# CITY OF ALBUQUERQUE

**Re: Blakes at Ventana Square Lot H2, Grading and Drainage Plan  
Engineer's Stamp dated 11-30-04 (B10-D8A)**

Drainage and
Grading Plan

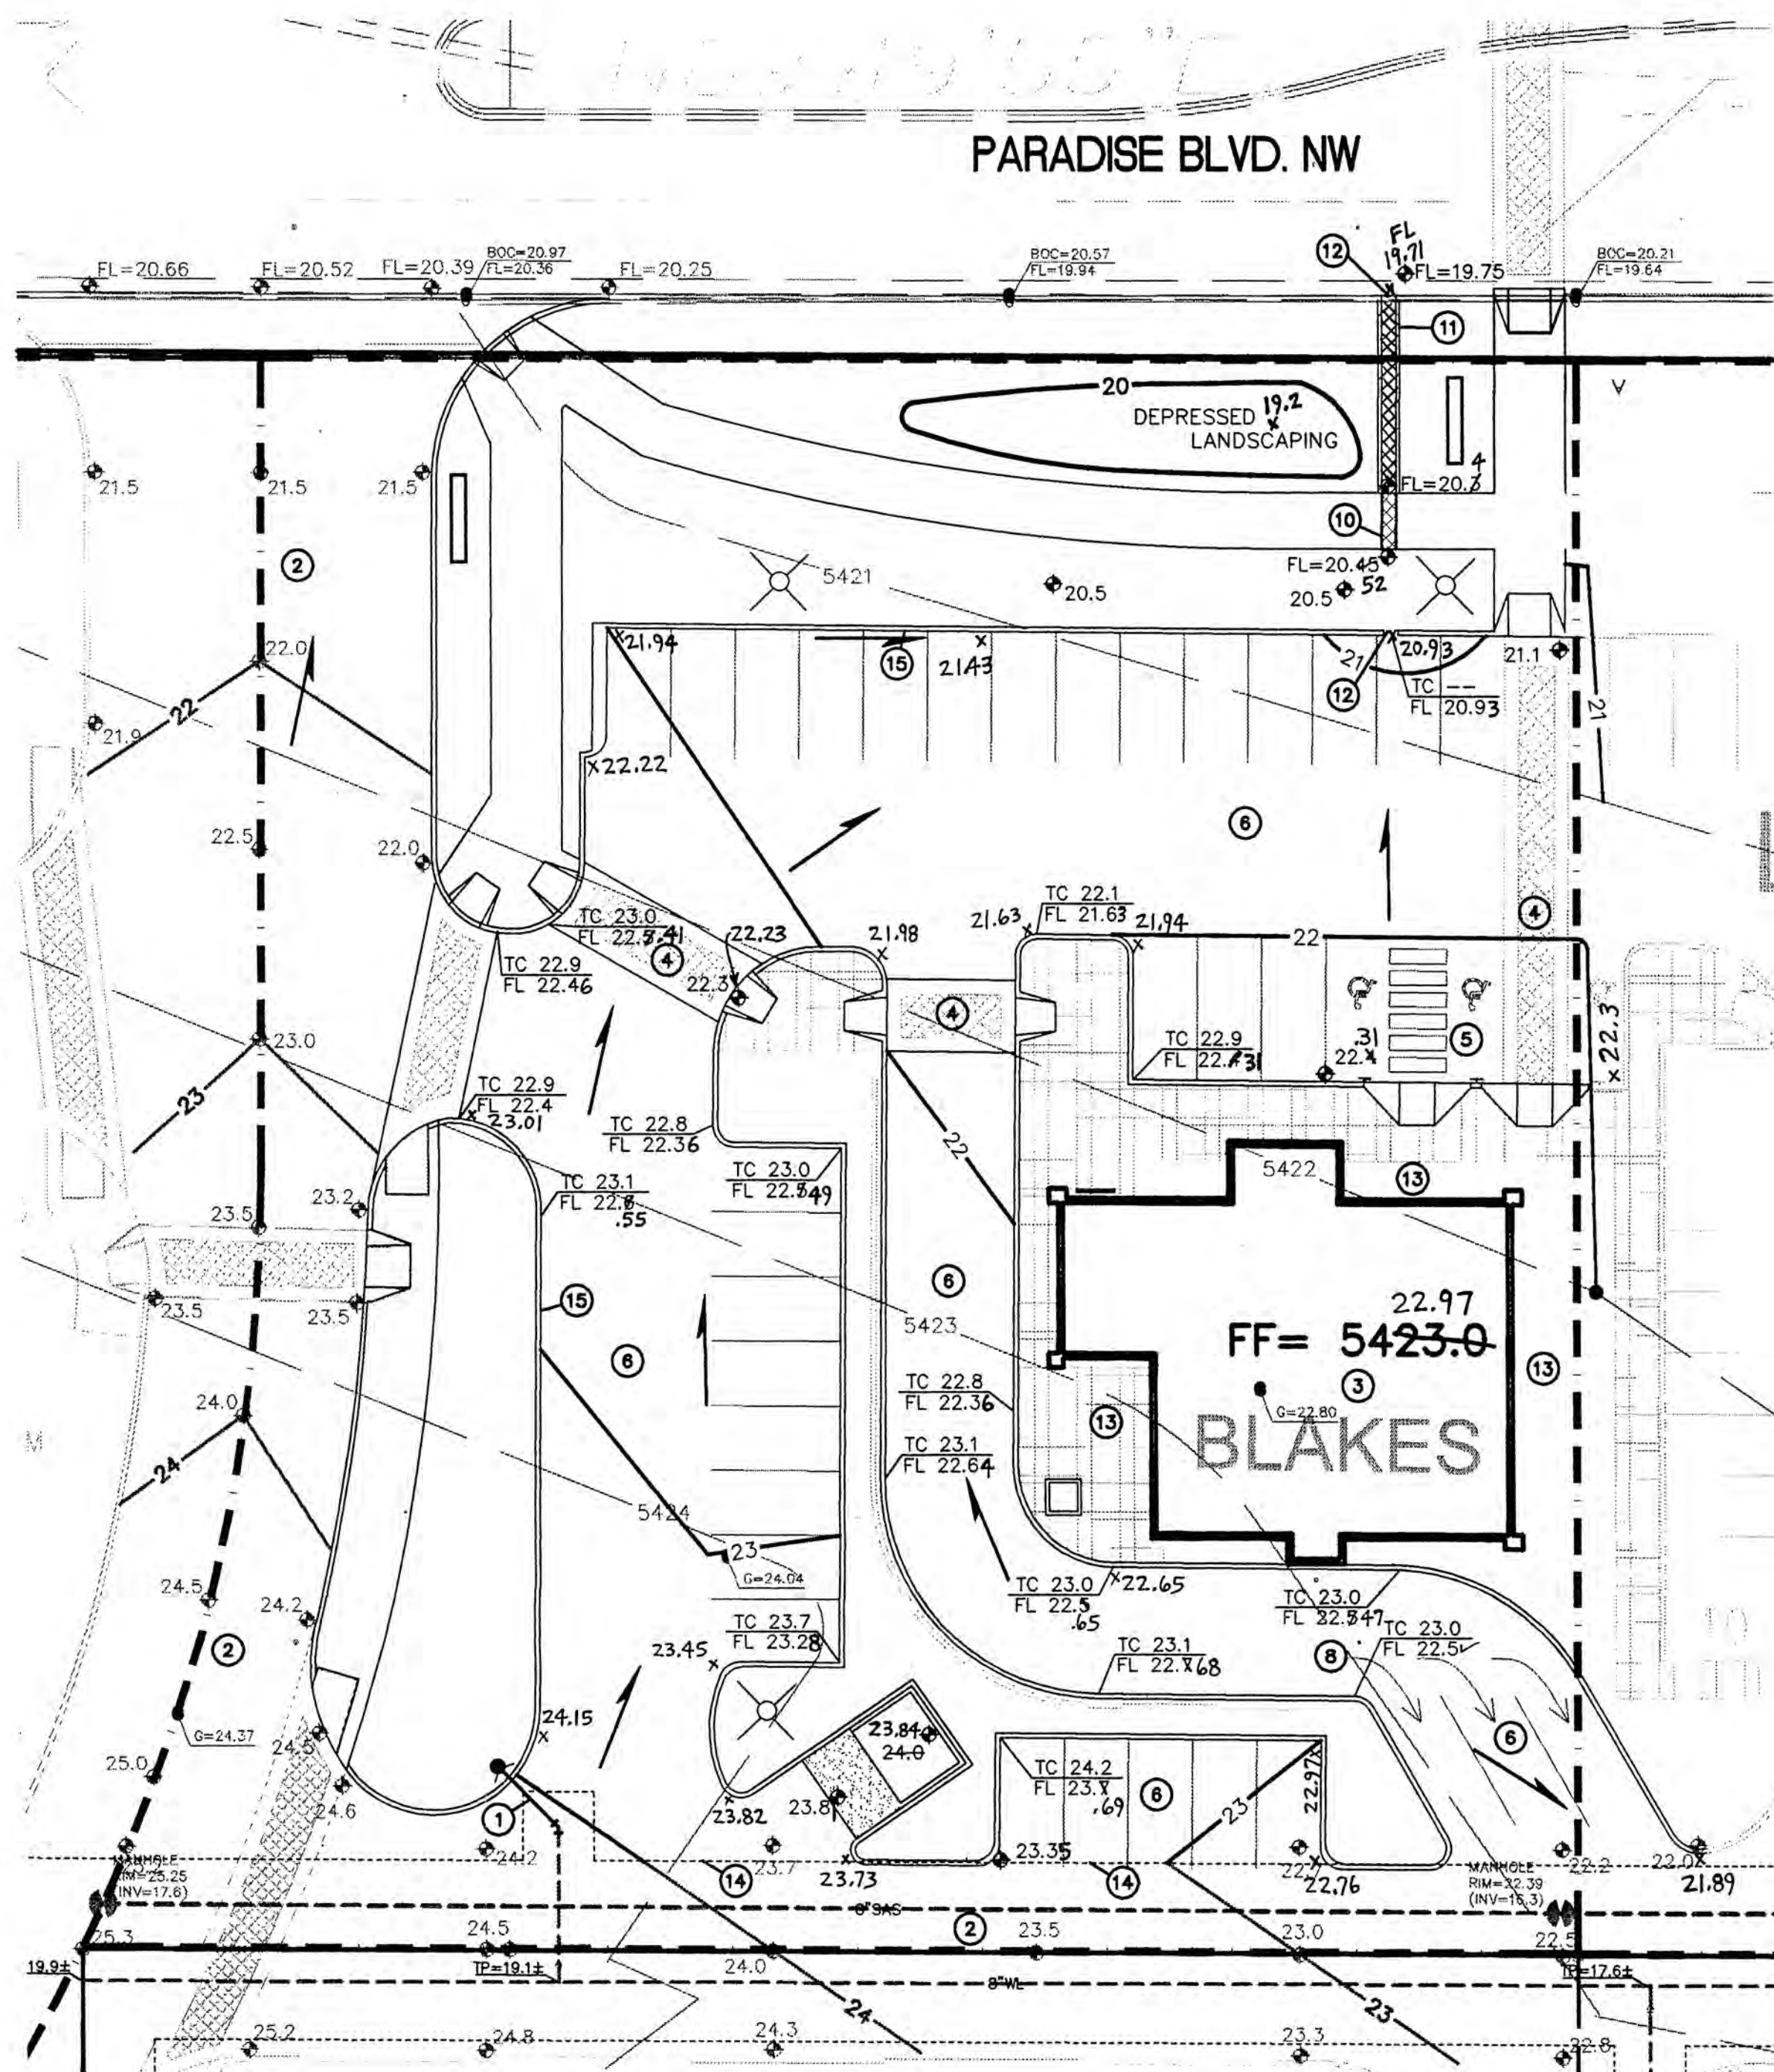
Based upon the information provided in your submittal received 12-01-04, the above referenced plan is approved for Building Permit. **However, the proposed concrete channel must be covered with a steel plate within the public right of way.** Please attach a copy of this approved plan to the construction sets prior to sign-off by Hydrology.
